From: Ian Gledhill [REDACTED]
Sent: 12 November 2020 13:54
To: Michael Eastham <Michael.Eastham@arun.gov.uk>
Cc: Planning.Responses <Planning.Responses@arun.gov.uk>
Subject: RE: Land at Water Lane, Angmering (A/109/20/RES) re-consultation

Hello Michael, please take these as the further formal views of WSCC Highways for the above planning application.

Reserved Matters Materials Layout Sheet (drawing no. A290-RM-702 P3)
Reserved Matters Materials Layout Sheet 1 (drawing no. A290-RM-701 P3)
Reserved Matters General Arrangement Sheet 1 (drawing no. A290-RM-101 P3)
Reserved Matters General Arrangement Sheet 2 (drawing no. A290-RM-101 P3)

Drawing No	Revision
A290-RM-701	P3

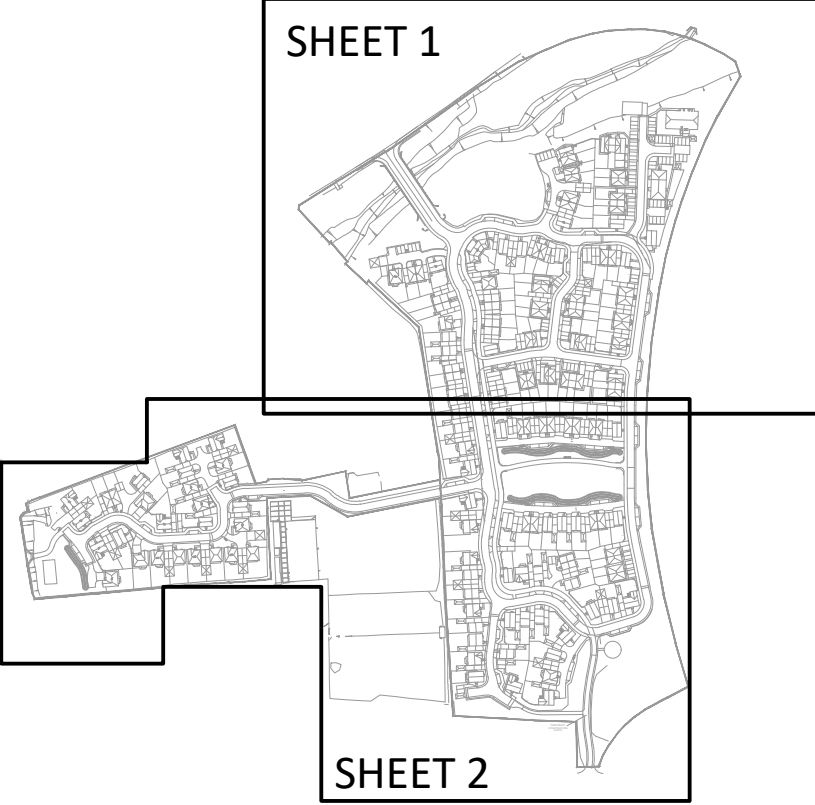
The majority of comments made by WSCC Highways on the 11th August 2020 have been addressed through the revised plans. Carriageway widths are noted to have been increased to 4.8 metres where concerns were raised previously. The access road serving plots 50-56 is now shown as having a footway rather than shared surface. This could have been retained as a shared surface although the arrangement as now shown is equally acceptable.

Regarding the north-south cycle route, no particular further assessment has been provided for this by the applicant although it's acknowledged that this was requirement was secured

through the outline planning permission. Viewed against LTN 1/20, the development would provide cycle friendly streets (i.e. low speed, lightly trafficked) and as such dedicated cycle infrastructure would not necessarily be required. Nevertheless the unsegregated route as shown would provide an alternate route for cyclists to use should they not be confident in using the carriageway.

There are no outstanding matters arising from the comments made initially by WSCC Highways. No new matters would be raised as a consequence of the revised plans.

No highway objection would be raised.
